RFI

RFI #: 68
Date: 2/29/2012
Job: EB-02 Keller Springs Lofts
Phone: 877-777-5115

Subject: Purposed change to the elevator detail on 9/S3.01

1 TYPICAL DRILLED PIER DETAIL
S3.01 NO SCALE

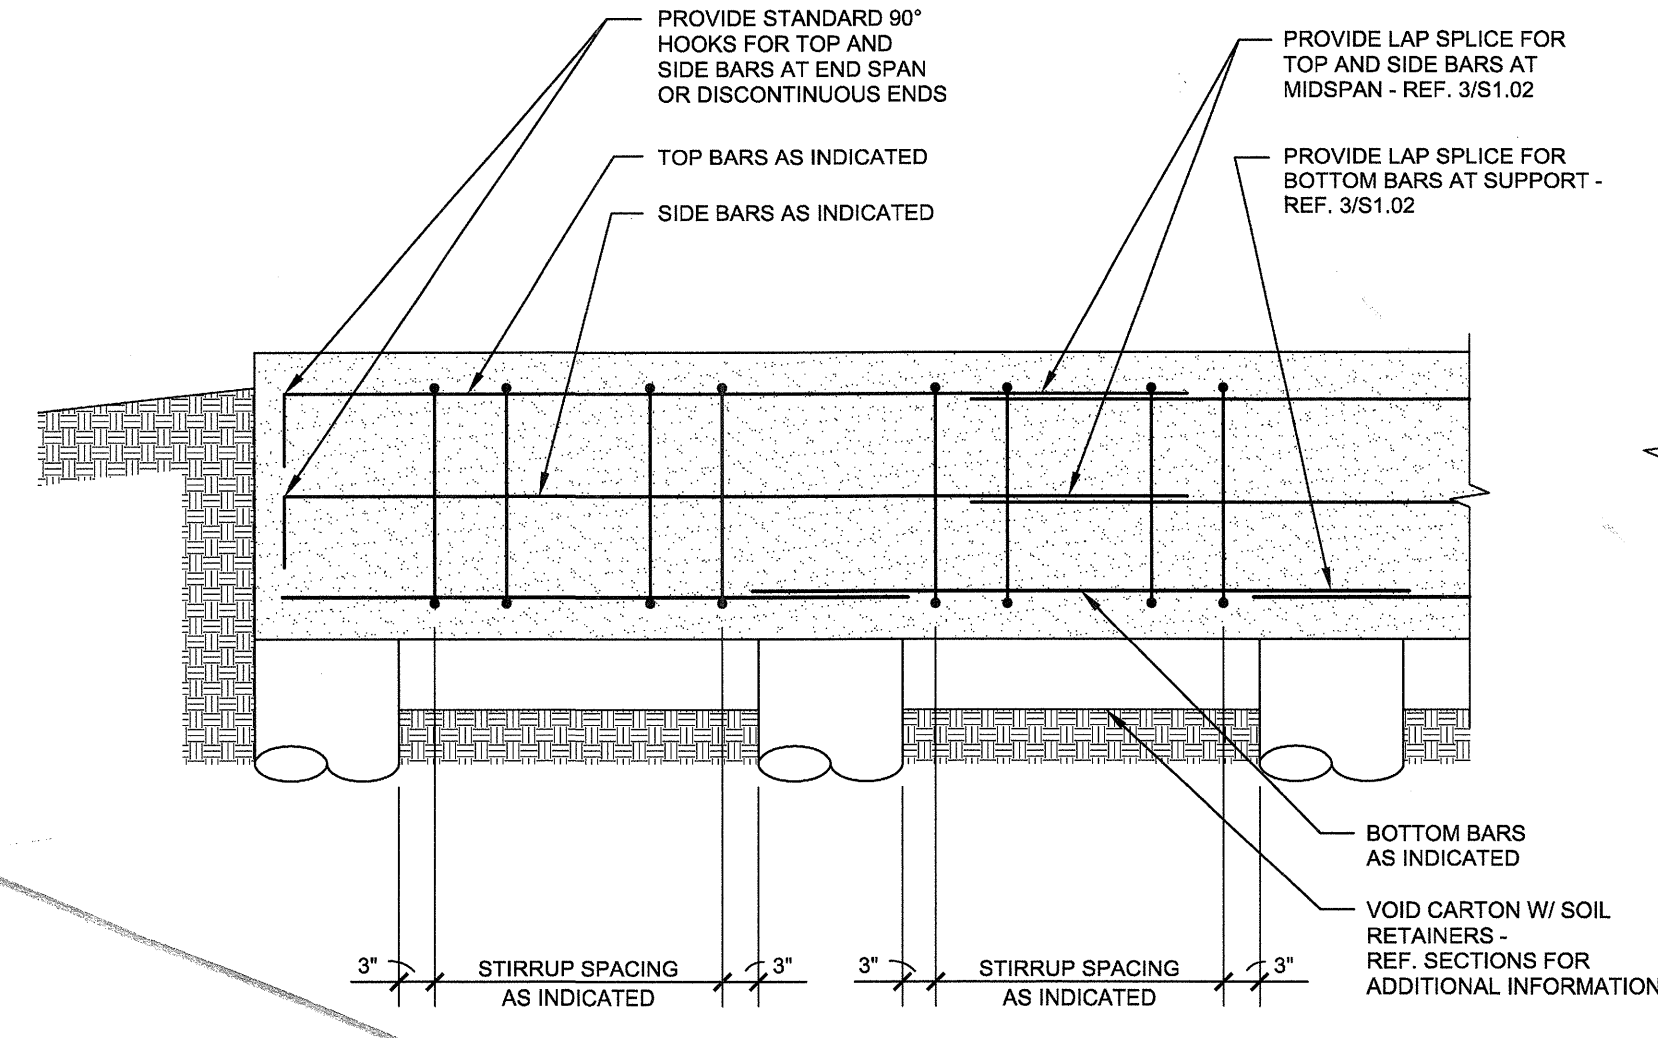
Subject: Dowels at Pier Caps

Request: Date Required: 3/22/2012
In our meeting on 3/16/12 at your office we discussed the already poured piers on slab pour #1 as having 4-#6x6'-0" dowels as shown on 1/S3.01 vs the proper detail as shown on 3/S3.02, which requires 6 #7 dowels. You were going to check to see if we can reduce the required number of #7 dowels to go along with the in place #6 dowels.

Please provide 4 - 7 "L" dowels in addition to the 4-#6 dowels currently in place. March 22, 2012
R. Trent Perkins, PE
Parkin-Perkins-Olsen Consulting Engineering, Inc.

6 SECTION  
SCALE: 1/2"=1'-0"

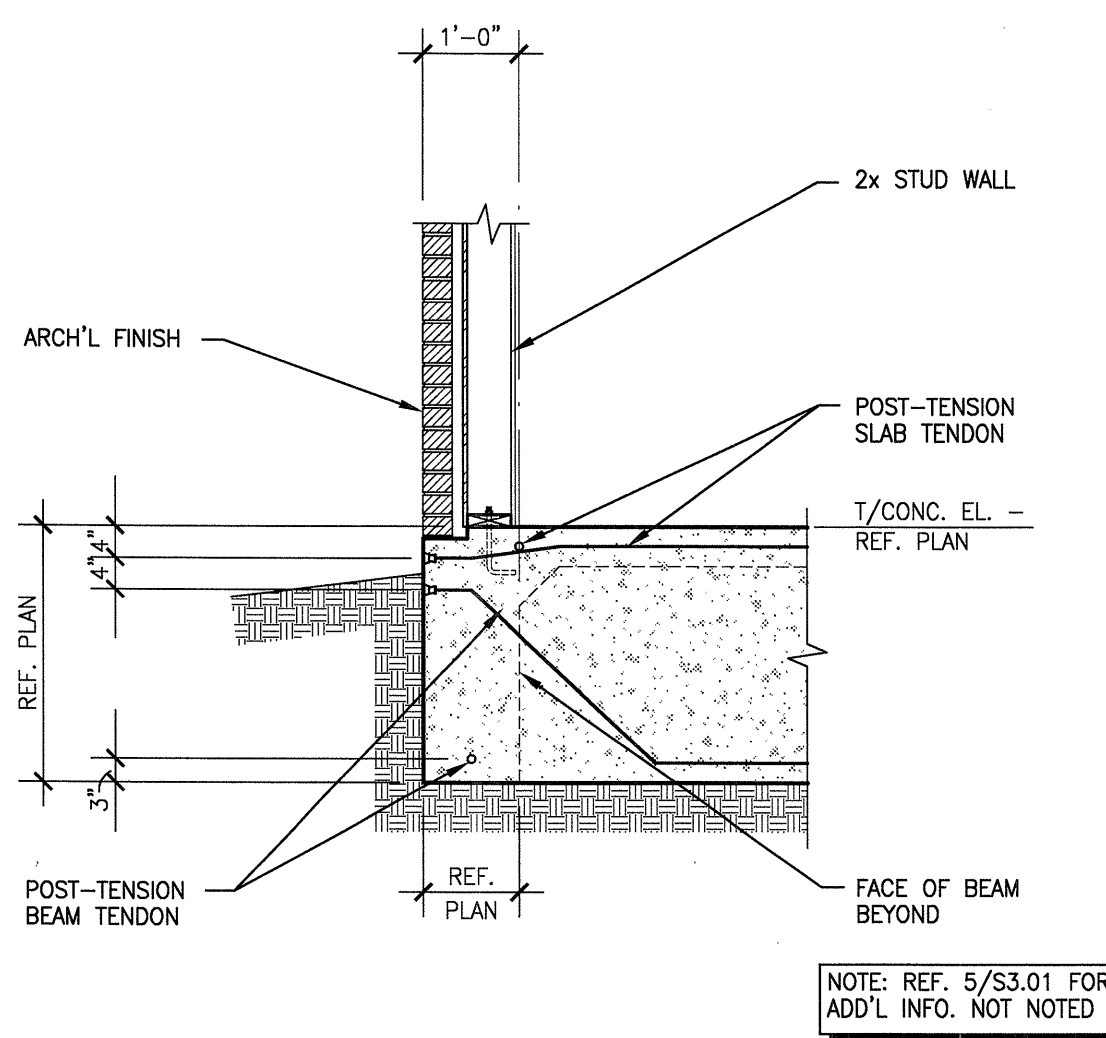
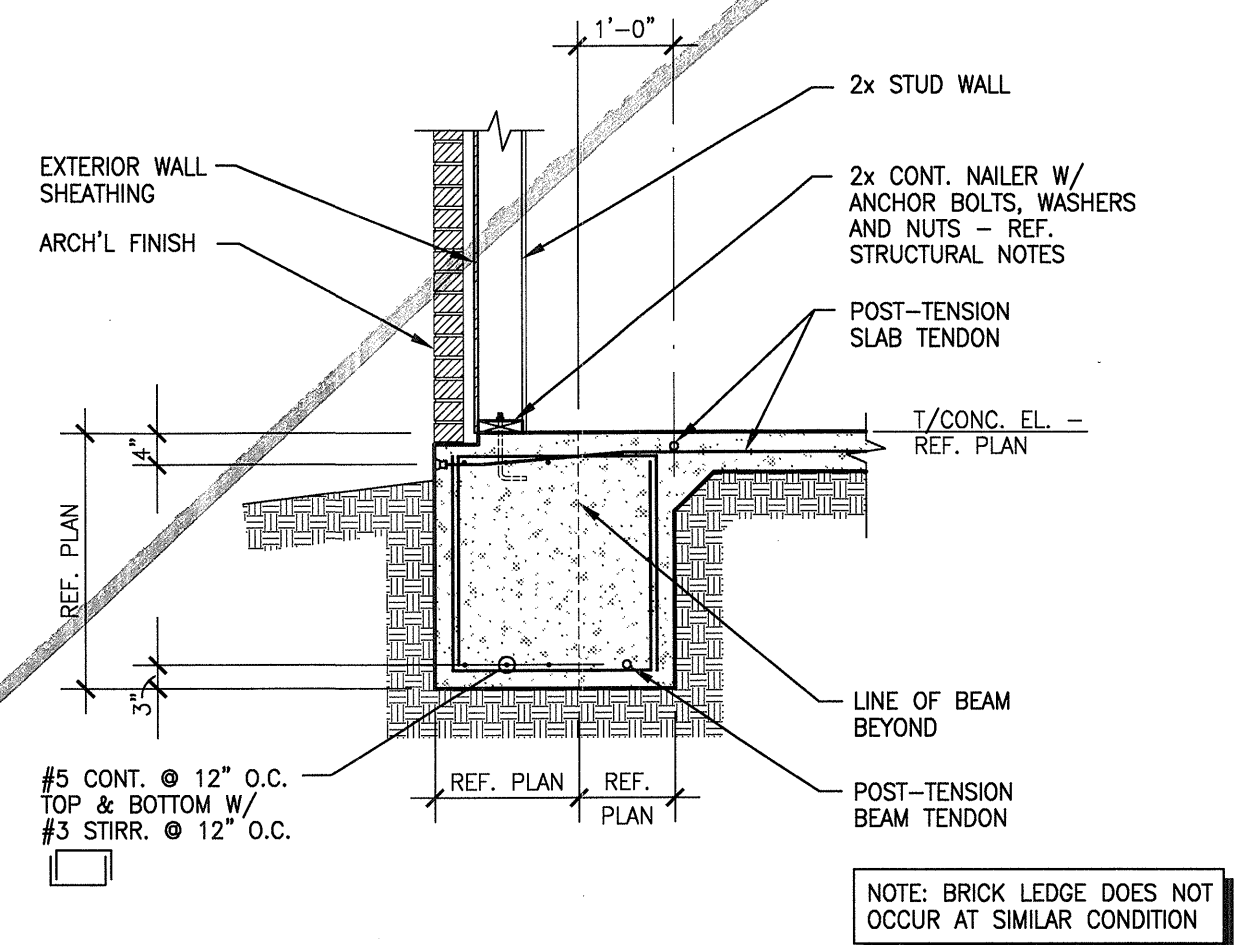
Subject: Grade Beam Drop Detail

Request: Date Required: 4/12/2012
There are several places on these sheets (there may be other sheets where this occurs) where a gradebeam changes elevation due to changes in top of pier elevation. On 2.11P, there are two entries into the building on the left side - one from the courtyard and one from the outside. The courtyard shows P9 piers that change to a P8A pier. Please provide details for this condition. A different condition would be on S2.13P where the interior piers (between Pours 3 and 5) are a P5 and the exterior pier is a P9. Please provide a detail showing how the grade beams come together.

Refer to details 6/S3.01 and 7/S3.01.
If you need additional clarification, please do not hesitate to call. April 11, 2012
R. Trent Perkins, P.E.
Parkin-Perkins-Olsen Consulting Engineering, Inc.
